DECISION DELEGATED TO HEAD OF PLANNING

Application No:	H04-0037-23	Applicant:	Mr & Mrs P Hilton
Proposal:	Proposed replacement dwelling		
Location:	11 Badgate Road Donington Spalding		
Terminal Date:	17th March 2023

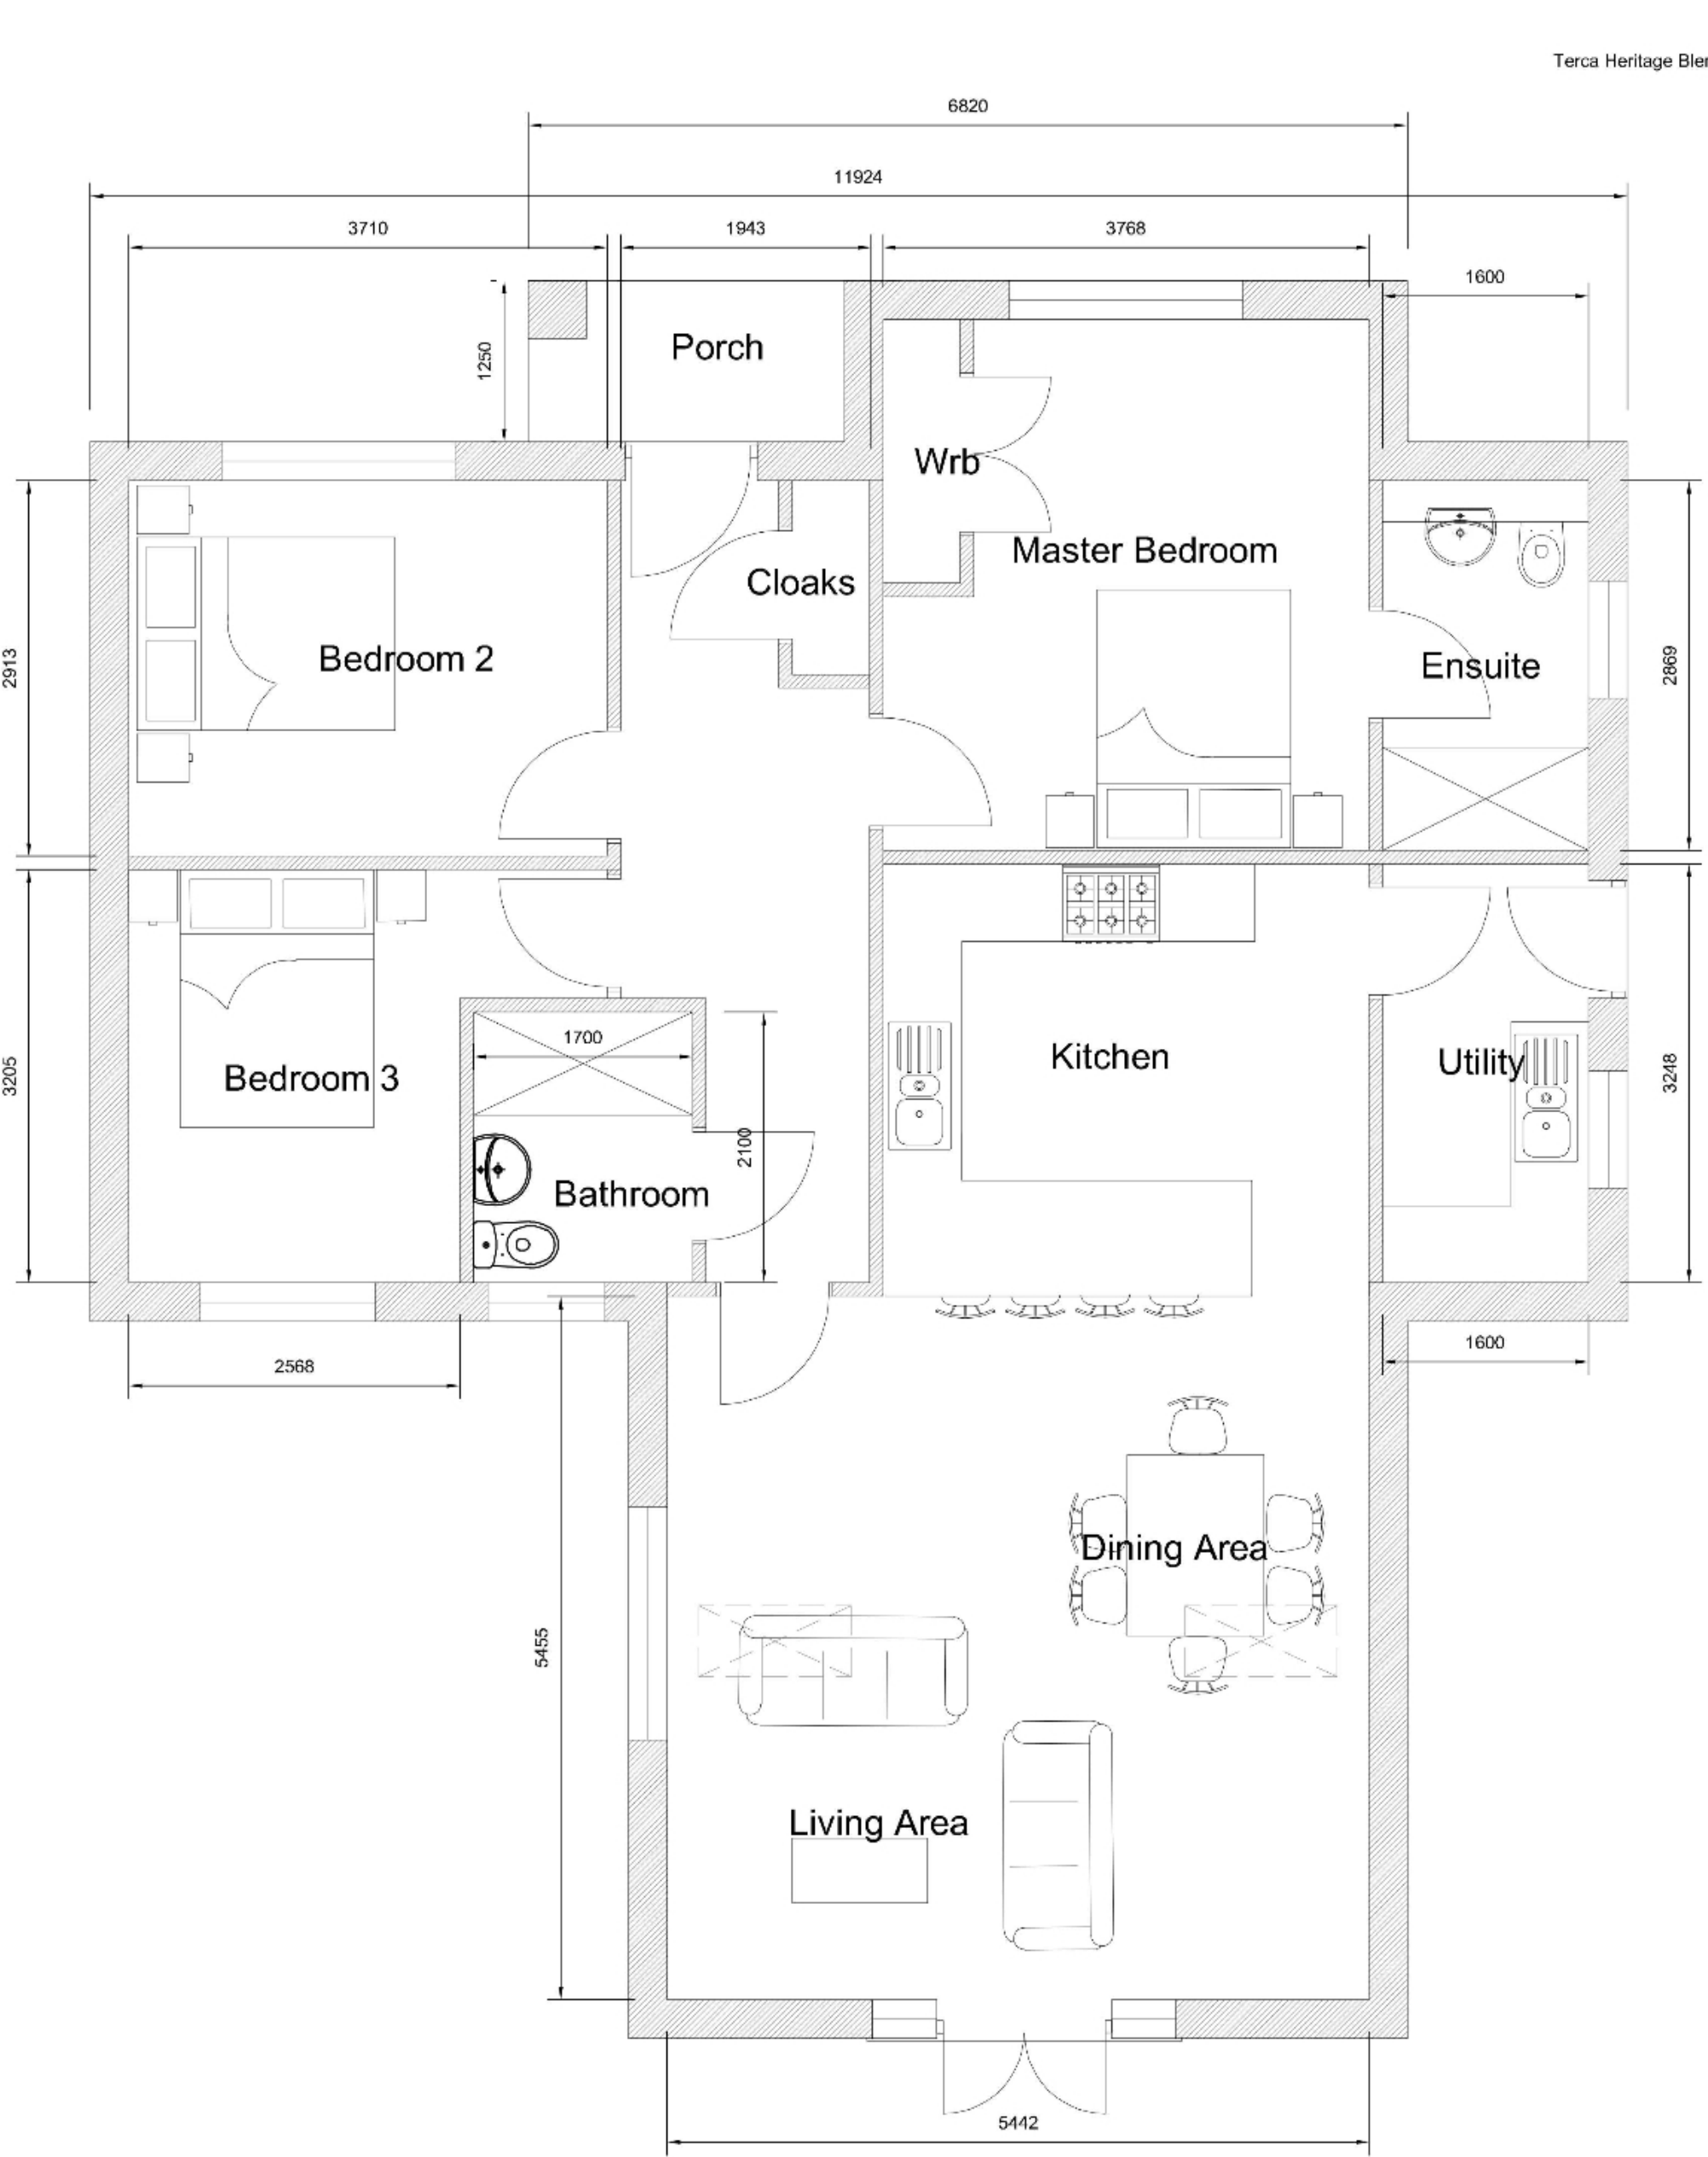
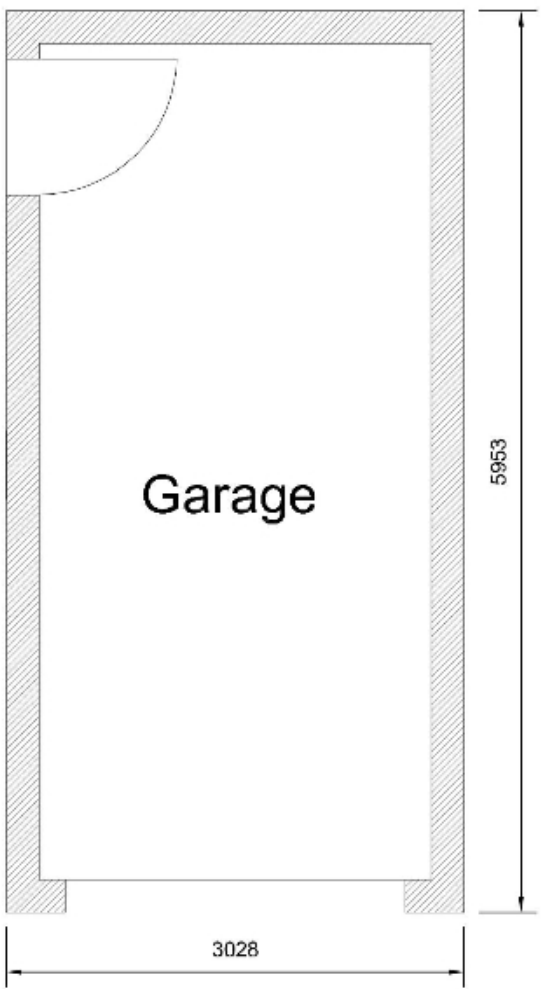
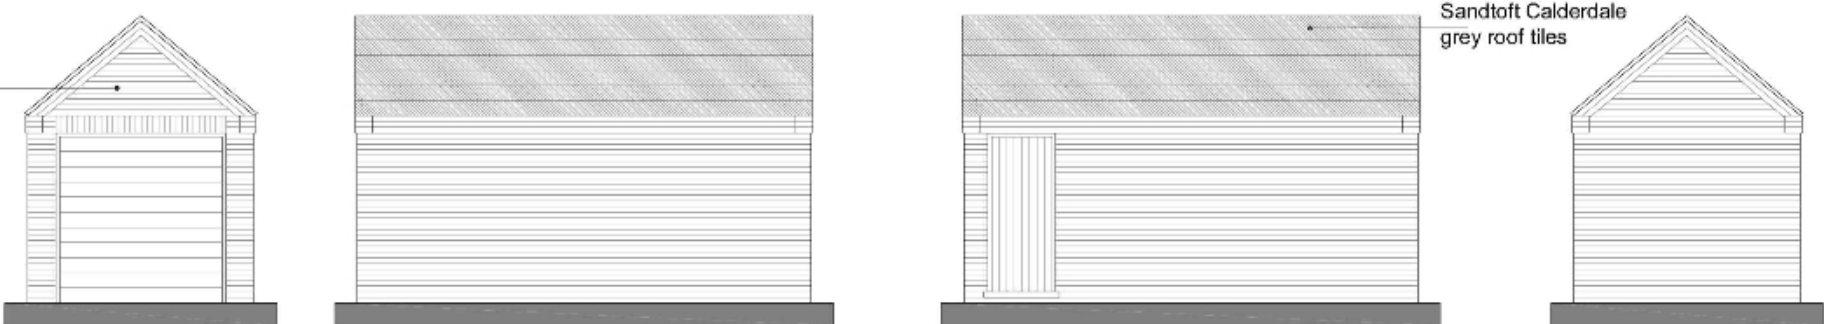
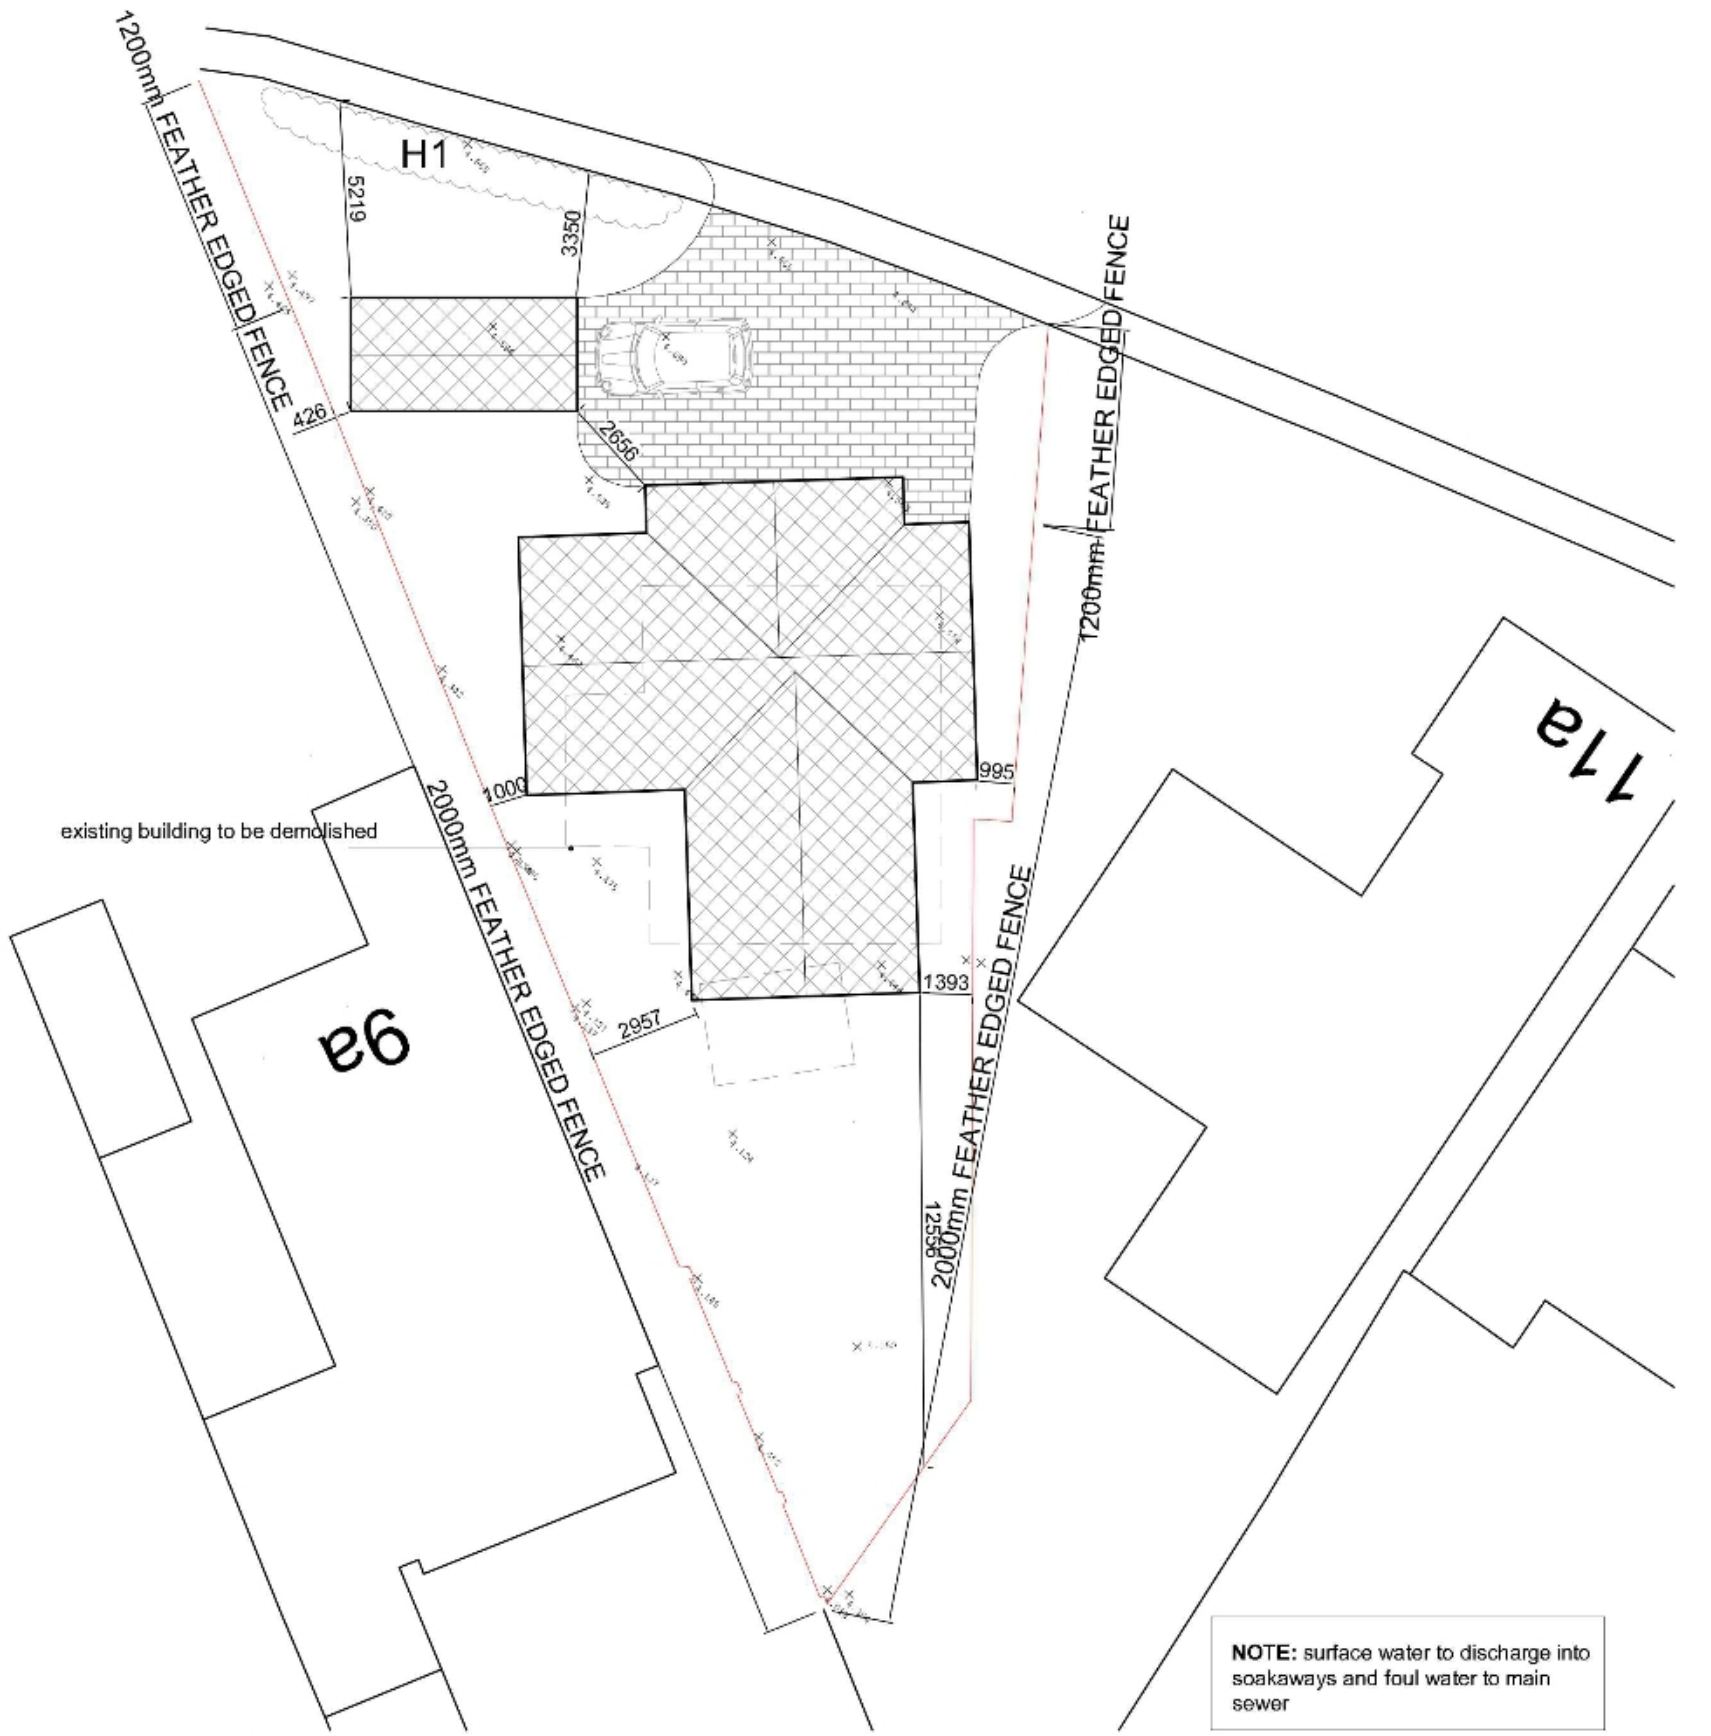
Overdevelopment - The proposal is not considered to represent overdevelopment. The replacement dwelling has a similar size footprint to the existing dwelling at 11 Badgate Road, albeit, set approximately 2 metres further forward. The proposed detached frontage garage is not of a scale, siting and design to be considered overdevelopment or imposing upon the highway.

Overshadowing - The ridge height of the dwelling is 5.42 metres above ground level. When an additional requested 300mm finished floor level is added to the dwelling to prevent surface water ingress this gives a total ridge height of 5.72 metres. When right to light lines are drawn the fenestration of neighbouring properties is not materially impacted. The height of the replacement dwelling is lower than that of the existing chalet bungalow.

7. The dwelling will be located in Environment Agency Flood Zone 1 and is not subject to increase hazard or depth on the 2115 South Holland Strategic Flood Risk Mapping. To prevent surface water ingress a finished floor level of 300mm above ground level will be requested to ensure that the dwelling is safe over the course of its lifetime.
